J. SMITH STRUCTURAL ENGINEERING, PLLC
N.C. CERTIFICATE NUMBER P-2212

September 19, 2024

RE: Pollino Residence
924 Ponchartrain Street
Fuquay-Varina, NC 27526
As-built footings and basement point load location

**S-1
 BASEMENT
 FOUNDATION PLAN**

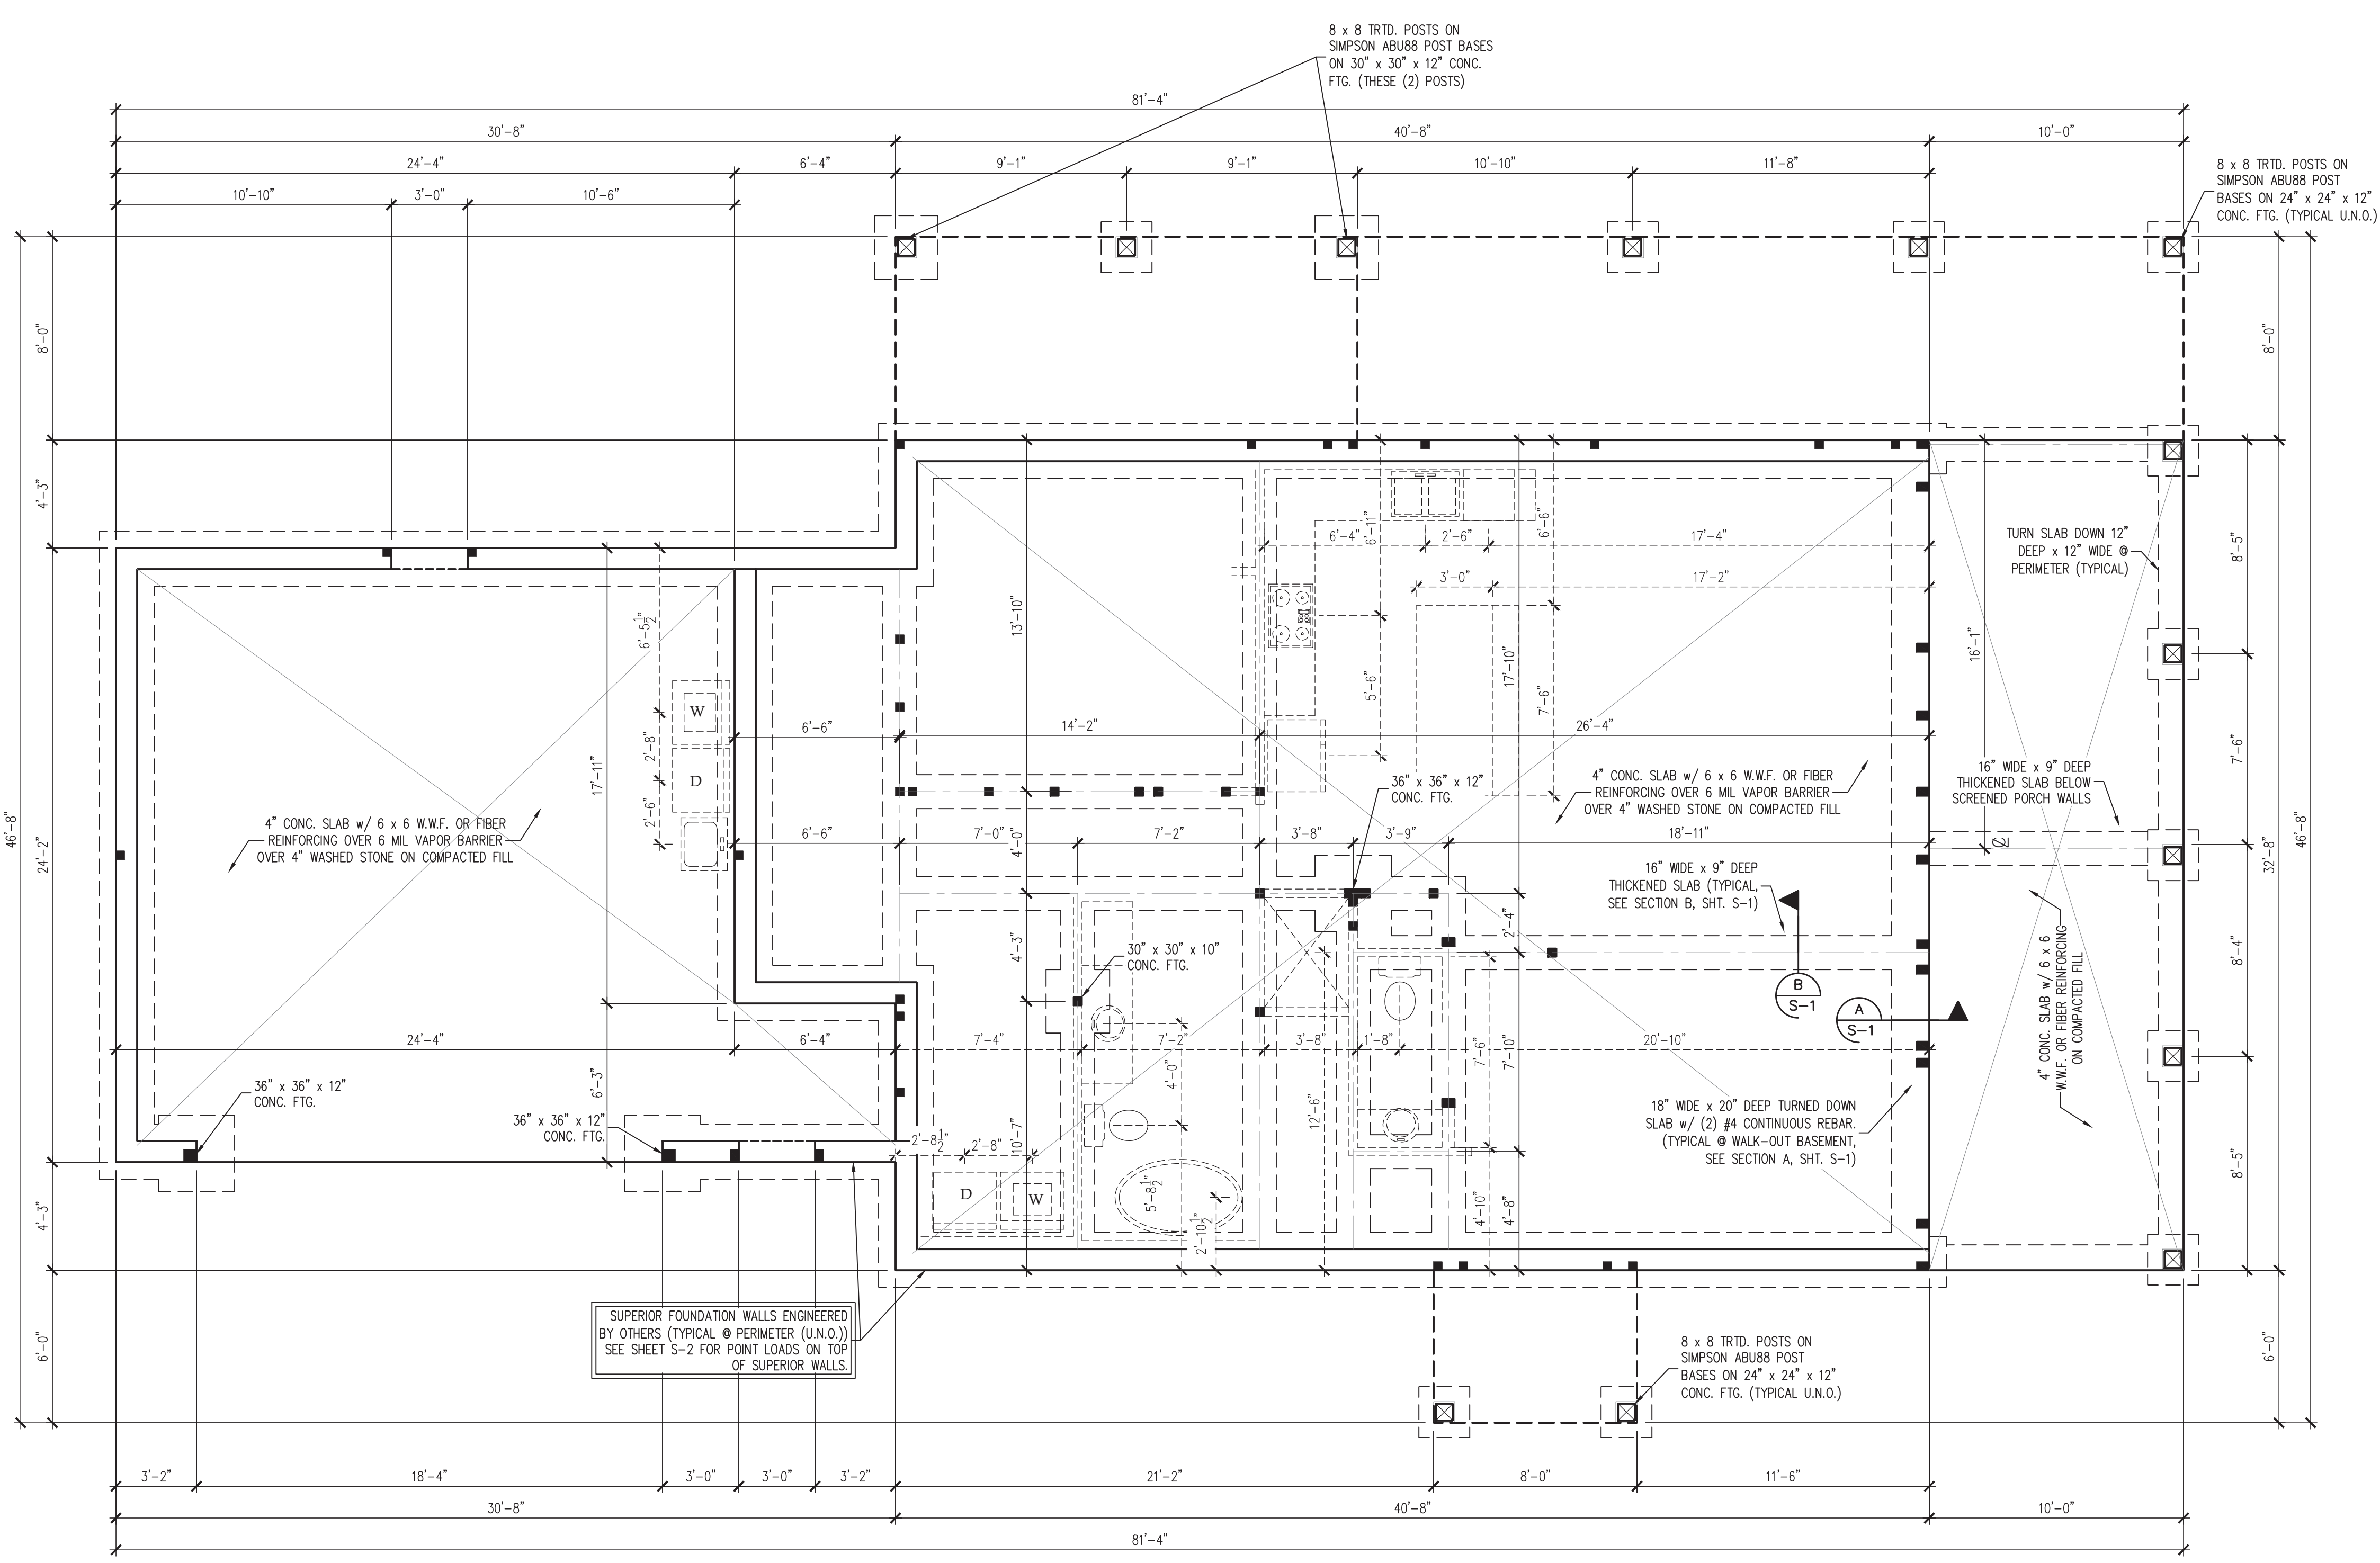
1. A base course of #57 stone was installed 12"-24" thick within the footprint of the basement including the perimeter superior wall footings.
2. All thickened slab and lug footings were installed per the engineered drawings except for the thickened slab below the front stair wall. The only point load along this wall bears on the 36" x 36" x 12" lug footing on the right side of the wall line. No other floor joists, ceiling joists, or rafters bear above this line.

4. At the (2) ply 9 1/4" LVL behind the stairway, a plumbing drop interfered with the location of the (5) 2 x 4 stud column at the center bearing point of the continuous beam. The (5) 2 x 4 stud column may be moved to the rear, 4" into the laundry room to clear the plumbing drop without affecting the load carrying capacity of the beam or the lug footing.

3. The 16" wide x 9" deep thickened slab below the front stair wall may be omitted and the as-built basement slab foundation is adequate to support all applied loads.
